Our Reference: P3378.003L

18 January 2019

RE : TWEED VALLEY HOSPITAL EIS RESPONSE TO SUBMISSIONS – TRANSPORT AND TRAFFIC

Project Name	TWEED VALLEY HOSPITAL CUDGEN ROAD AUXILIARY LANE WORKS
Drawing Title	AUXILIARY LANE TRAFFIC CONTROL DEVICE PLAN

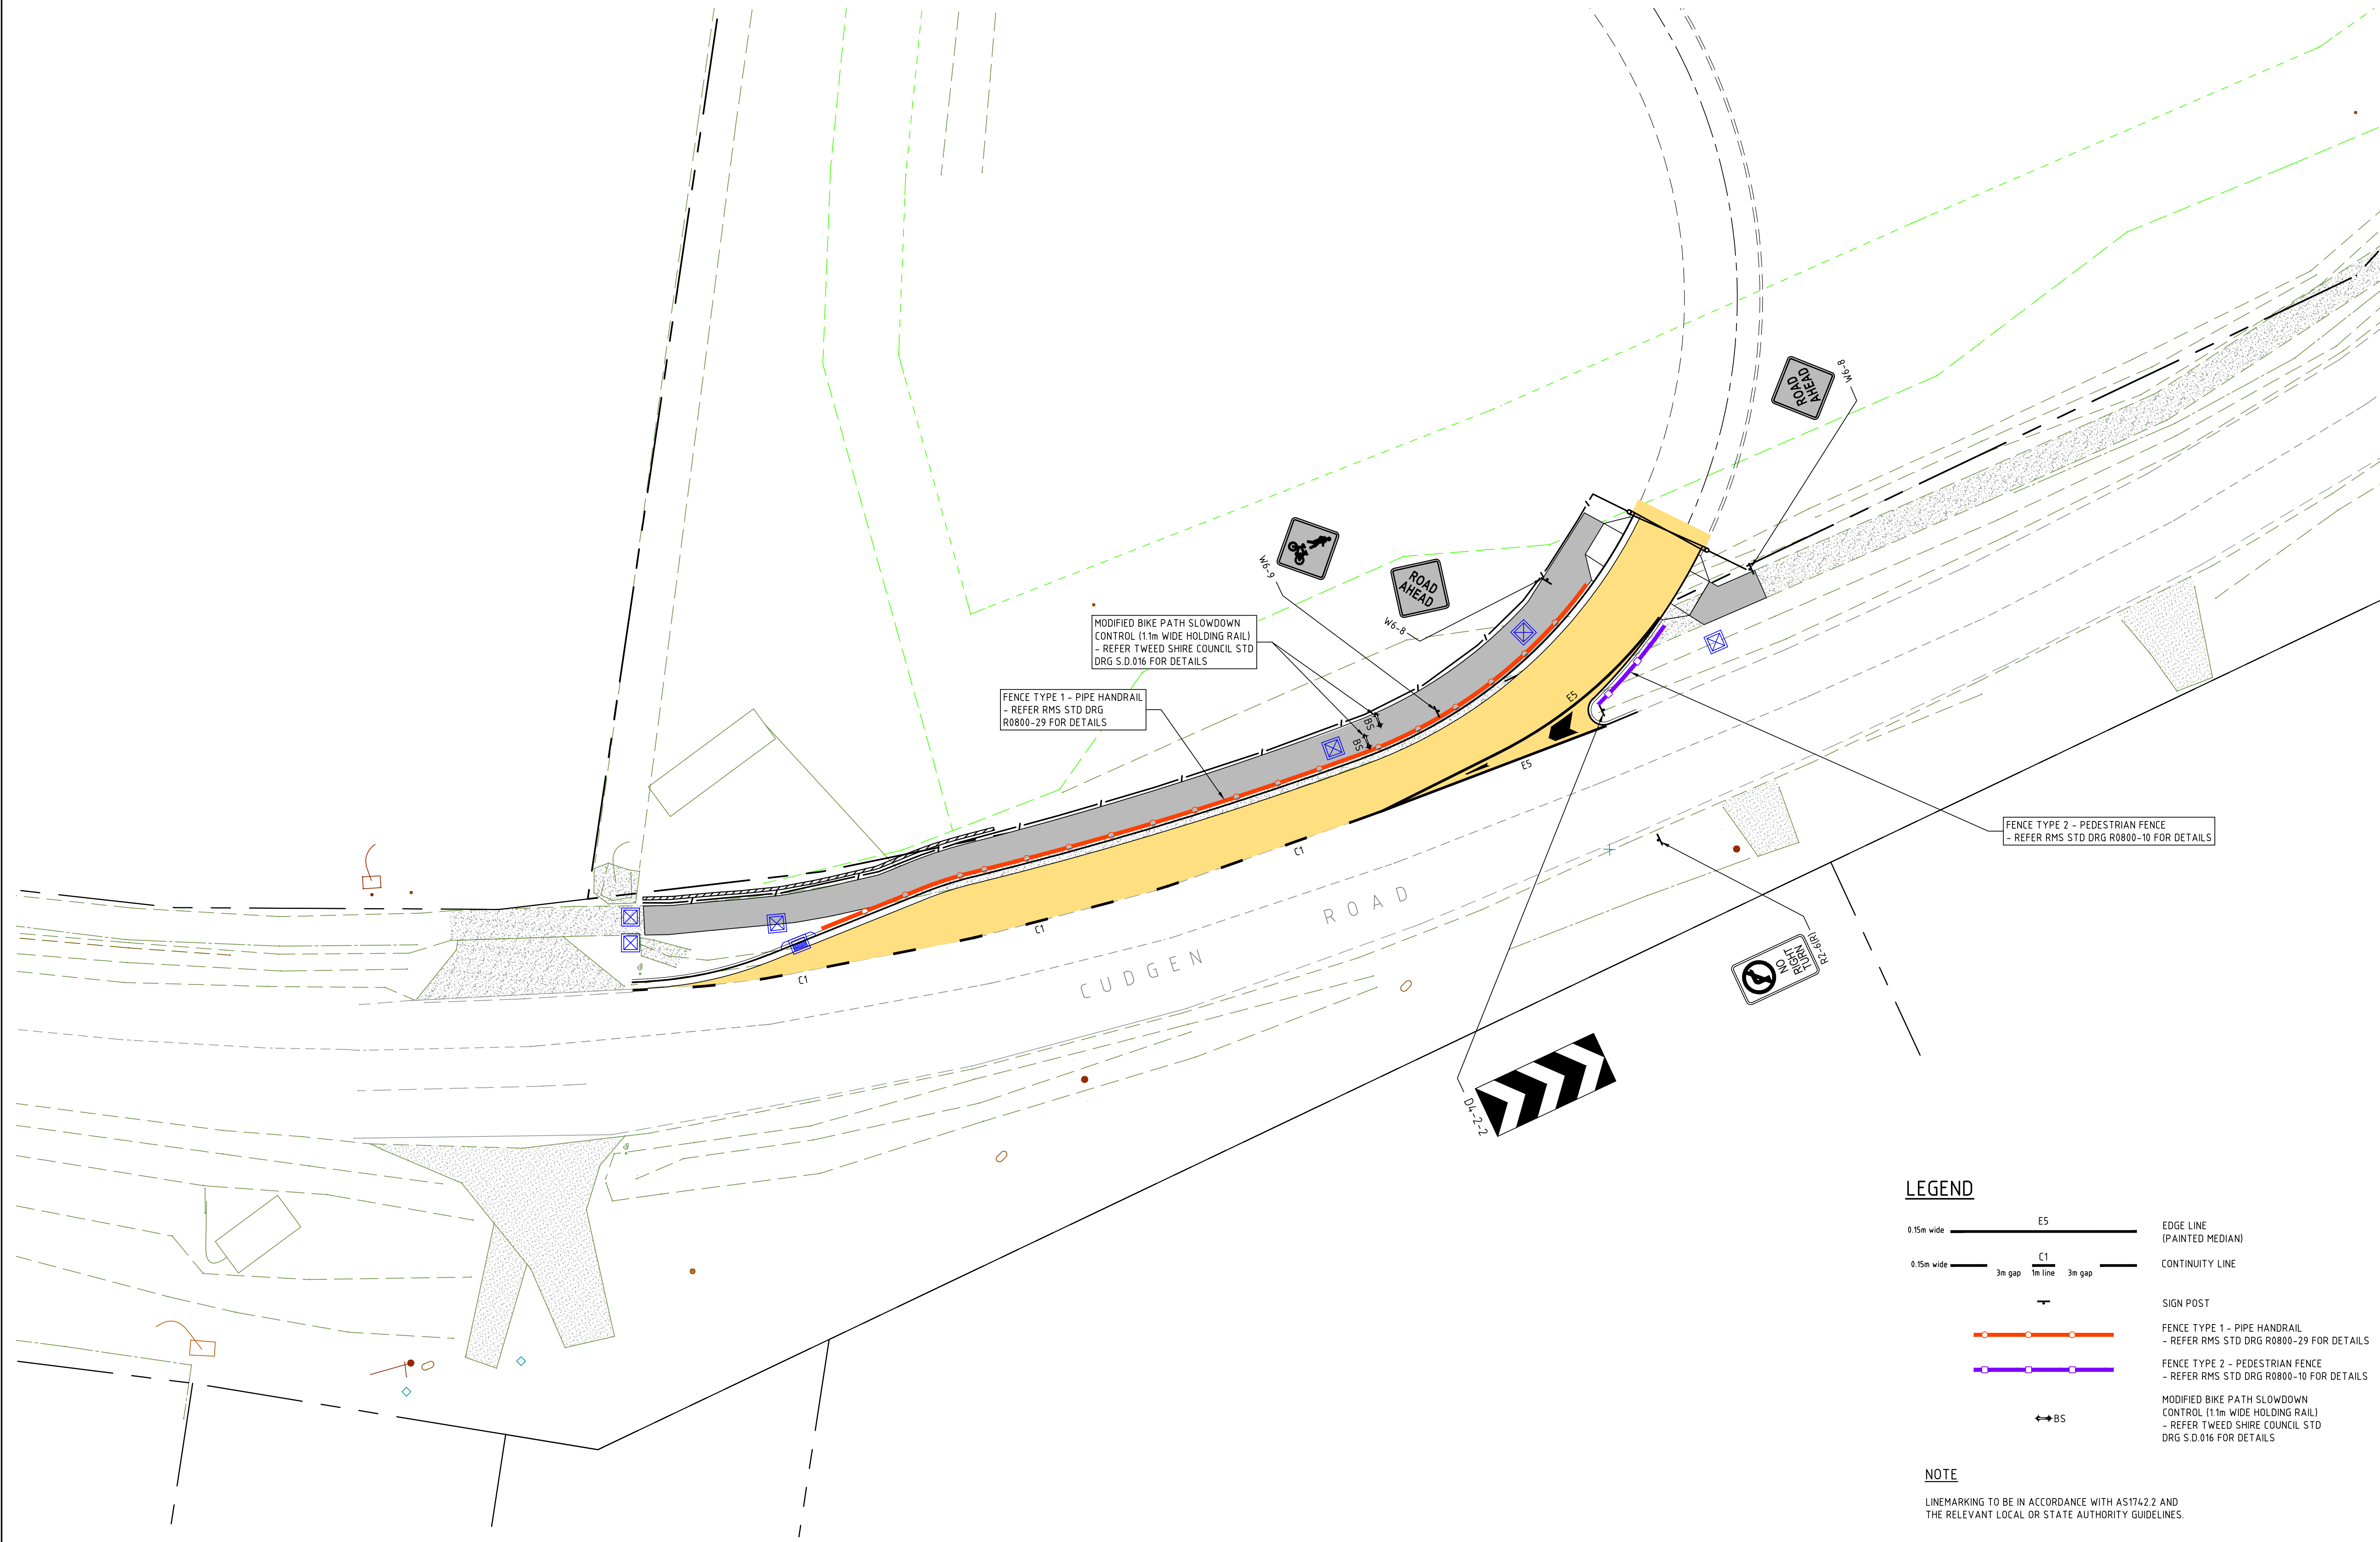
Left in only from Cudgen Rd at eastern boundary. The applicant has advised that the western access was designed for use by authorised vehicles only accessing the site via Tweed Coast Road (West). This was used to justify the design of the access to a "higher order treatment" "in accordance with Austroads design and turn warrants." However, it is noted in the concept design that direct access from this access is provided to the Staff Carpark and this is acknowledged in the Traffic Report on page 45. The report does not identify that the access bisects a shared user path and the potential risks for the existing users of this facility.

It is recommended that should the higher speed access design be pursued then internal access to the Staff and Public Carpark should be removed from this entrance.

G. Access A off Cudgen Road is to be modified to reflect the requirements of Council's Driveway Access Specifications and connect orthogonal to Cudgen Road in a similar configuration to the Byron Bay Hospital access from Ewingsdale Road.

The appropriateness of Access A has been reviewed in the response to Section 4.2 of this letter. subsequently, the access arrangements are proposed to remain as per the EIS submission. Additional safety measures can be investigated as part of detailed design including signs and line marking for both users of the shared path and for vehicles as well as pedestrian fencing, and bicycle chicanes / bollards.

- Access A is now also proposed as part of Stage 1 Early Works (refer Section 7.0);
- the design of Access A has been amended to address safety concerns. The amended design notes that RMS approved pedestrian fencing is to be installed adjacent to the ancillary lane to ensure that pedestrians cross at the pram ramp, appropriate pedestrian cyclist chicanes to be installed to RMS/Austrroads requirements and signage to be installed on the shared advising of the road ahead; and
- Council Technical Officers noted acceptance of the design with the above-mentioned amendments. Council Technical Officers recommended approval of the s138 application for the access (with the abovementioned amendments) as documented in "Agenda – Ordinary Council Meeting Wednesday 12 December 2018". For further details refer Section 7.0.
